**From:** Dunderdale, Chris <Chris.Dunderdale@lancashire.gov.uk>  
**Sent:** 14 October 2019 12:22  
**To:** planning  
**Subject:** RE: Consultation on application to discharge conditions 3/2019/0870 Land east of Chipping Lane, Longridge

The application is for discharge of conditions 8 (drainage strategy) and 11 (construction management plan) of planning permission 3/2017/0232.

Job	Chipping Lane Longridge		
Task	Surface Water Drainage Area Plan		
Design By	Date	Drawing Number	Rev
CD	Feb 2016	459/ED/04	B
CAD By	Scale		
CD	1:500 @ A0

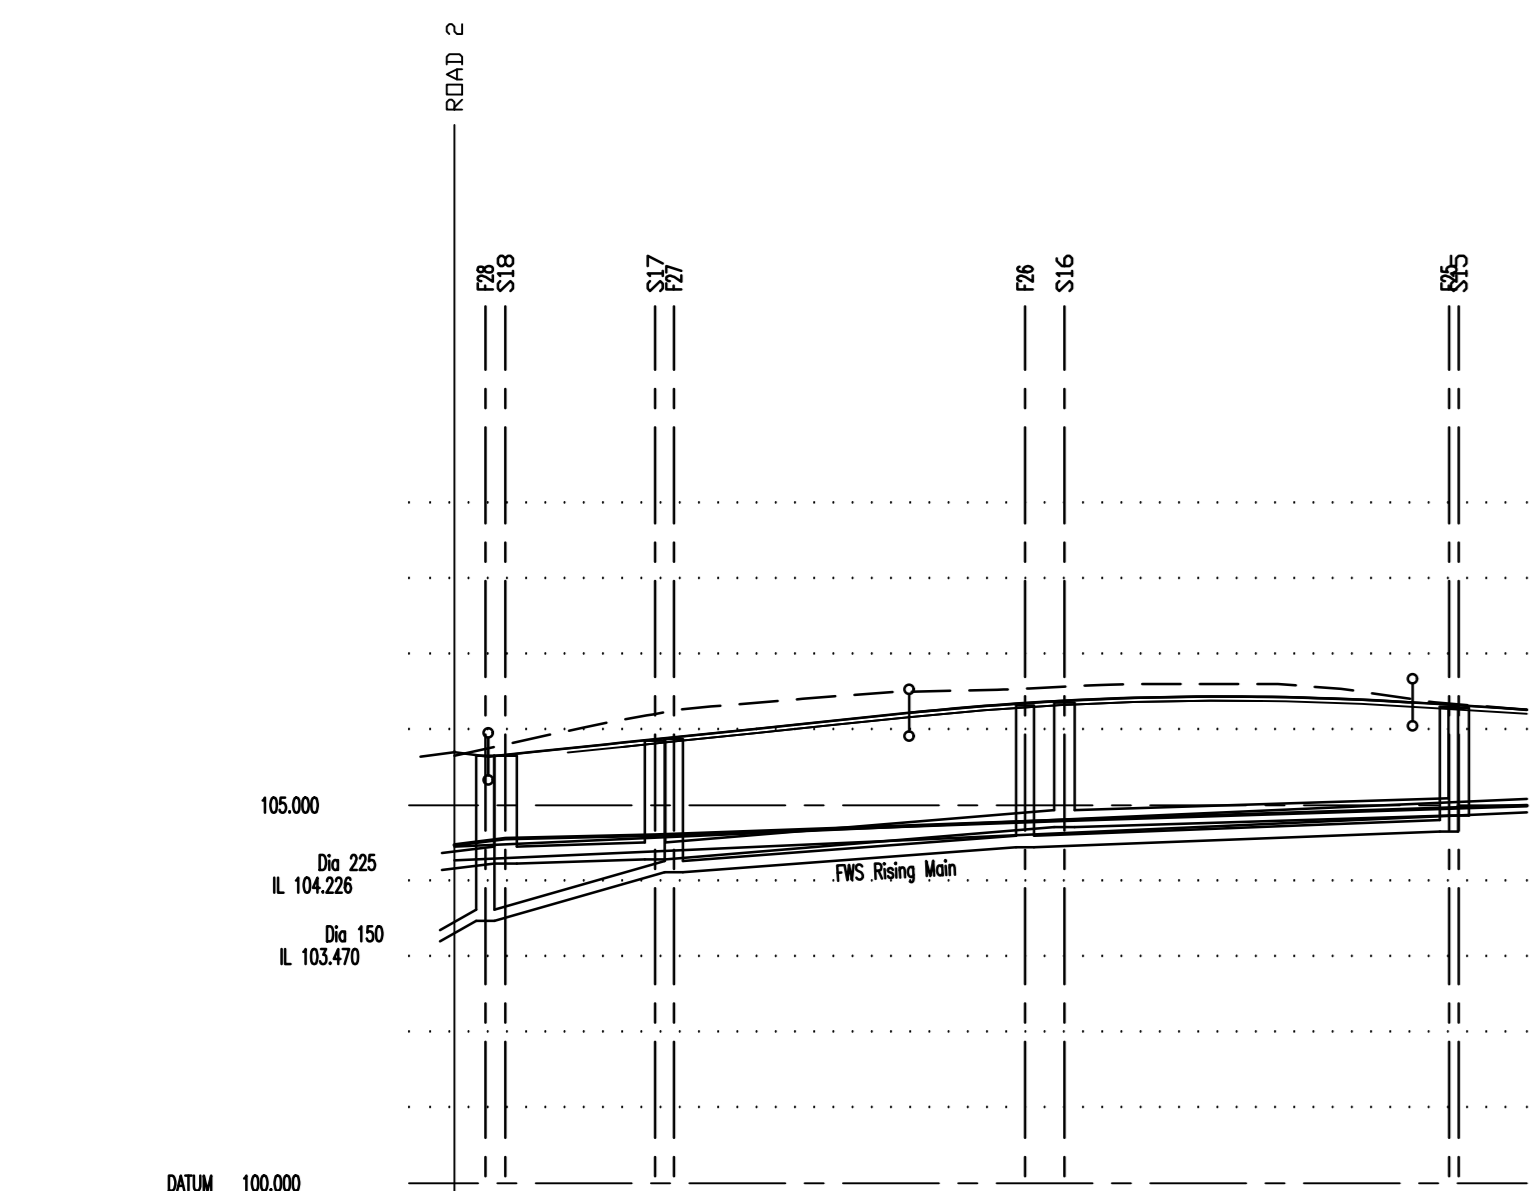
Having read through the applicant's drainage strategy report, I can see that the intention is for surface water runoff to be restricted to a maximum rate of 50.05l/s. As far as I can tell, that rate has been based on an allowable discharge of 8.3l/s/ha spread over a what is claimed to be a 6.03ha developable area. However according to the information shown on drawing 459/ED/04 Rev B, only half of that area is actually intended to be positively drained. The remaining area will presumably retain its existing runoff characteristics post development and should therefore be excluded from the greenfield runoff calculations. This is in line with the methodology outlined in section 24.2.2 of the CIRIA SuDS Manual, 2015. Doing so, would likely result in a significant reduction to the maximum surface water runoff rate for this phase of the development. Please can you bring this to the attention of the applicant so that it can be adequately addressed. Please can you also ask the applicant to clarify how they intend to account for urban creep within their drainage design.
